Please upload the email below which is a consultation response from **ADC Drainage Engineers** to planning application **A/76/20/PL** relating to Dappers Lane and the provision of a footway along the eastern side of the lane.

**From:** Paul Cann <[Paul.Cann@arun.gov.uk](mailto:Paul.Cann@arun.gov.uk)>  
**Sent:** 29 September 2020 15:13  
**To:** Michael Eastham <[Michael.Eastham@arun.gov.uk](mailto:Michael.Eastham@arun.gov.uk)>; Stuart Burnett [REDACTED]  
**Cc:** Clark, Robert [REDACTED]  
**Subject:** RE: D1260 Dappers Lane - Highways

Proposed Footway Tie-in

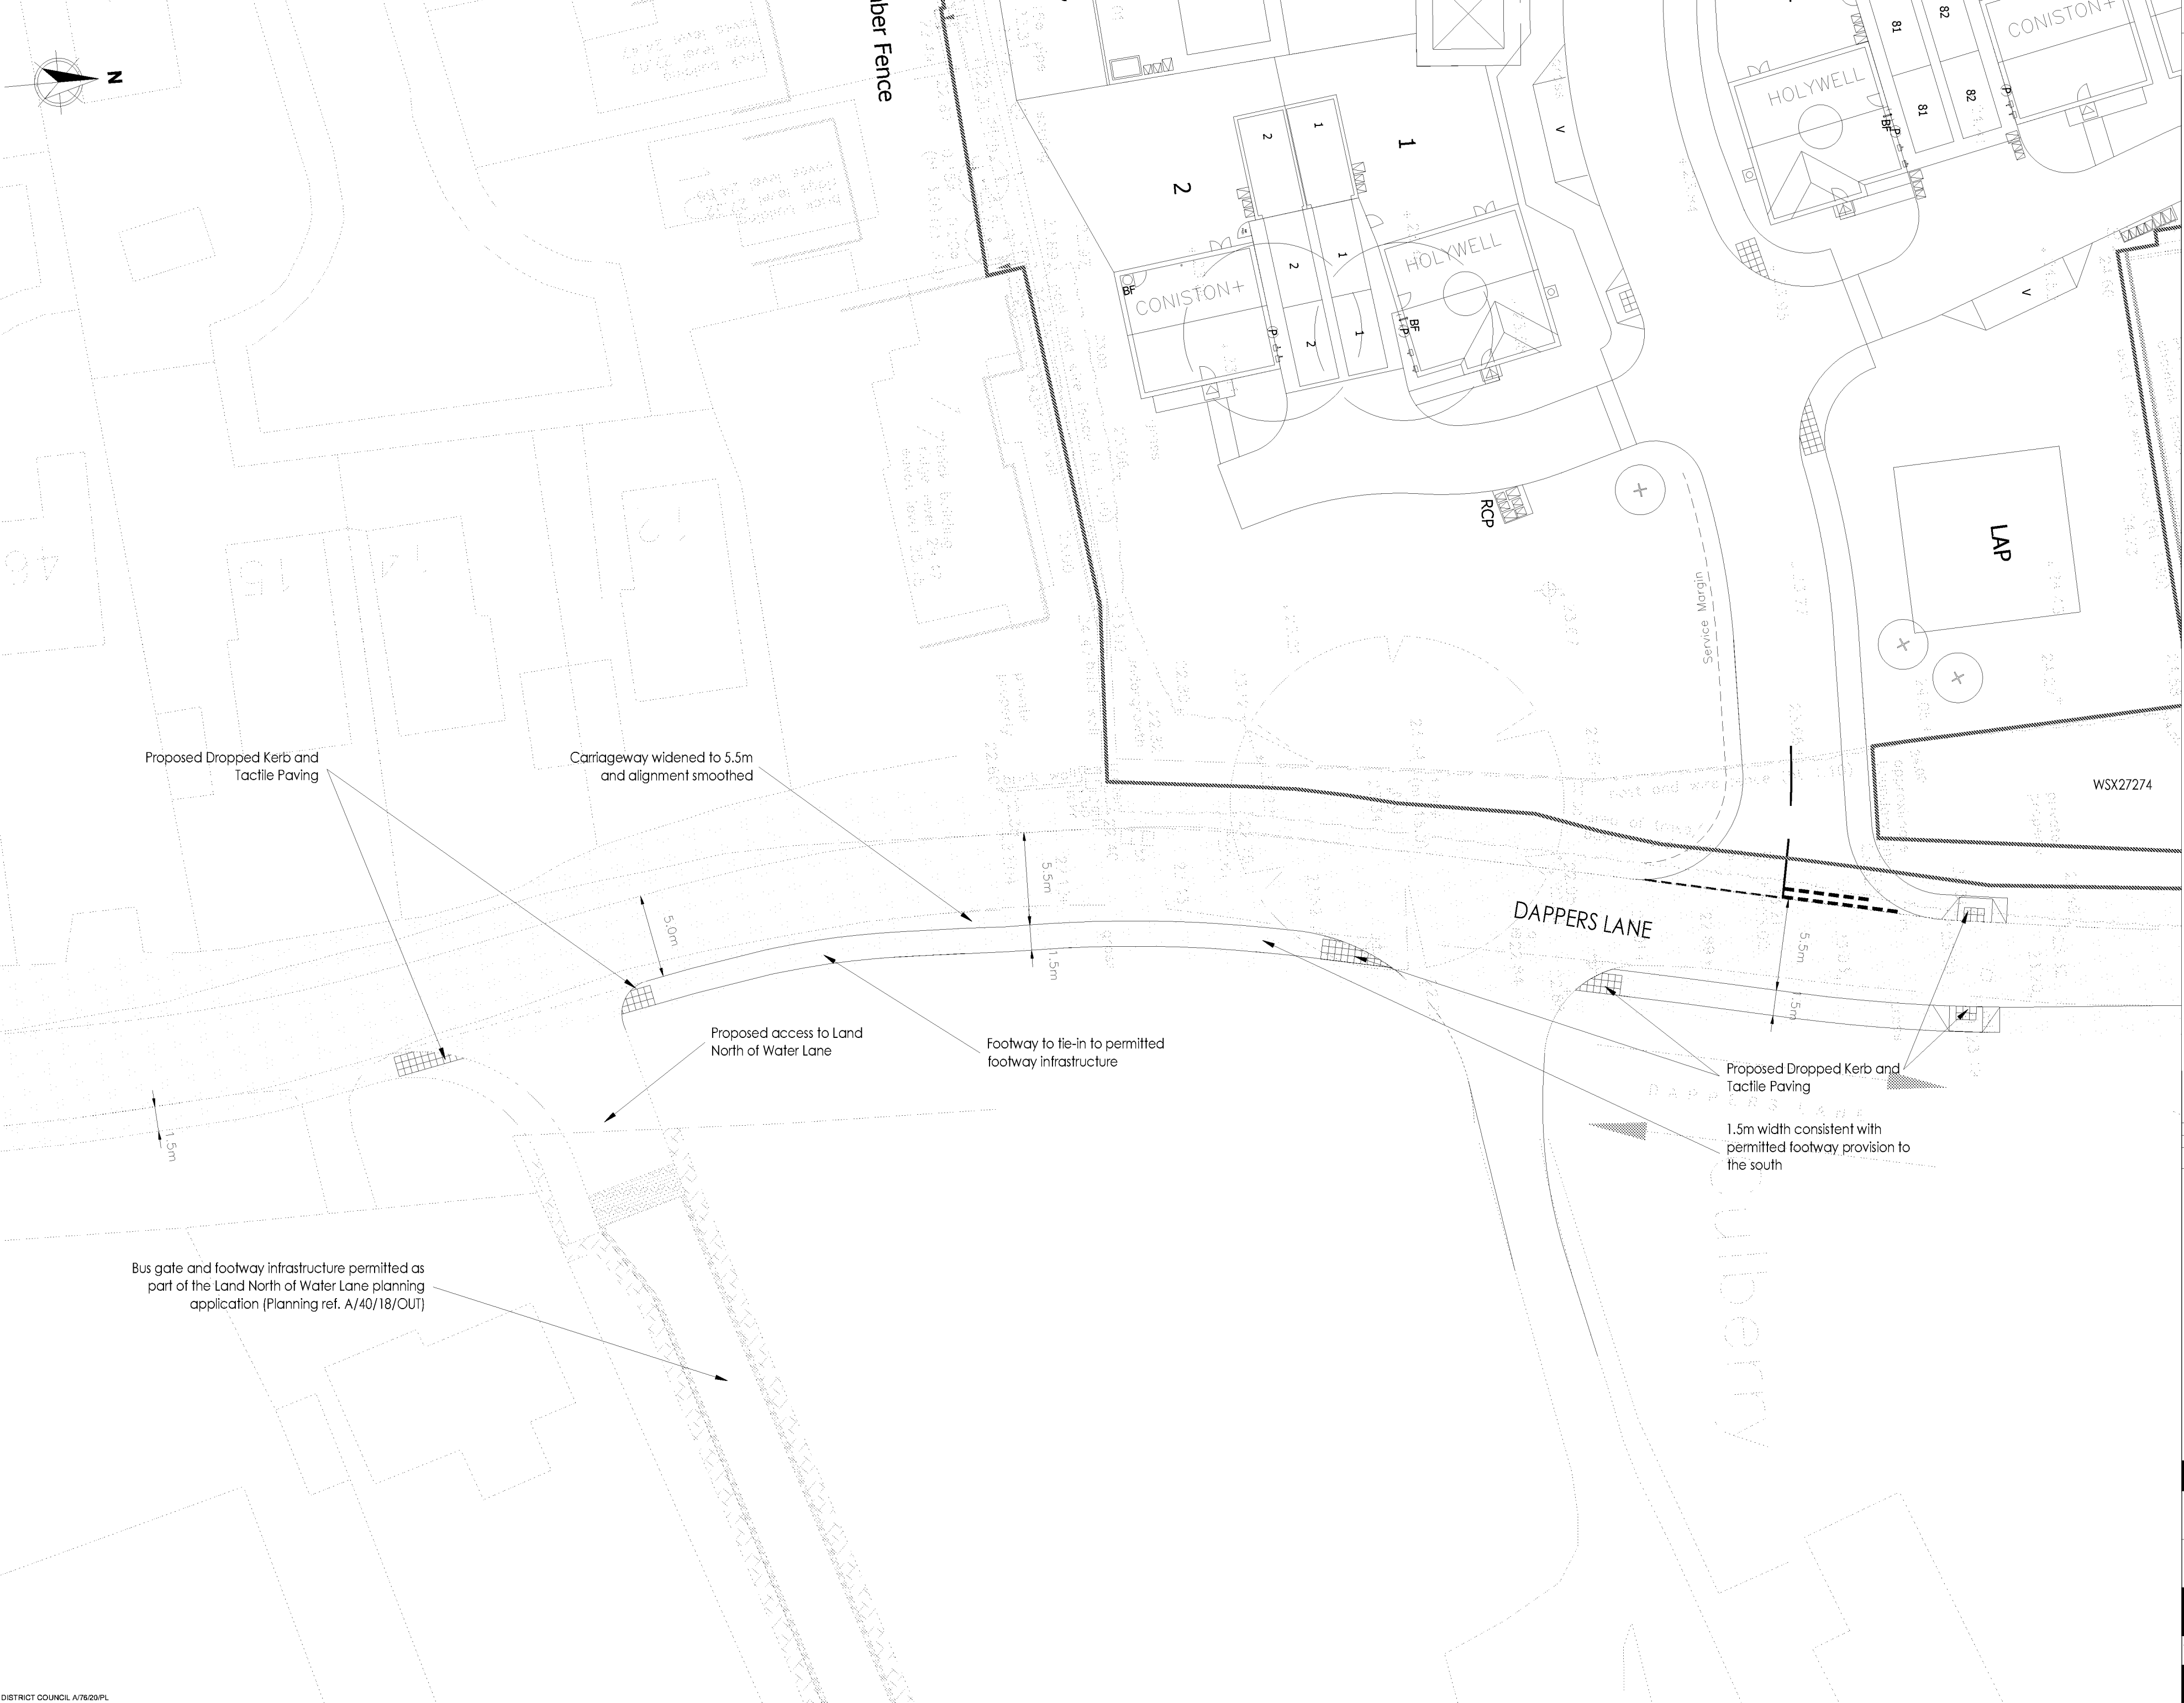
Based upon discussions with Stuart and Rob on site, we believe it is possible to install the footpath on the eastern side of Dappers Lane, from the site itself up to the driveway of 'Greenways' (opposite 15 Woodlands Close) without too much impact on the watercourse. We would expect some minor works to the ditch to facilitate the proposals which will be dealt with during the detailed design.

Our concerns relate to a continuation of the footpath on the eastern side, south of 'Greenways' driveway and beyond. In order for us to understand any impact on the ditches/culverts, we need to see more detailed drawings of the proposals from whoever is preparing them.
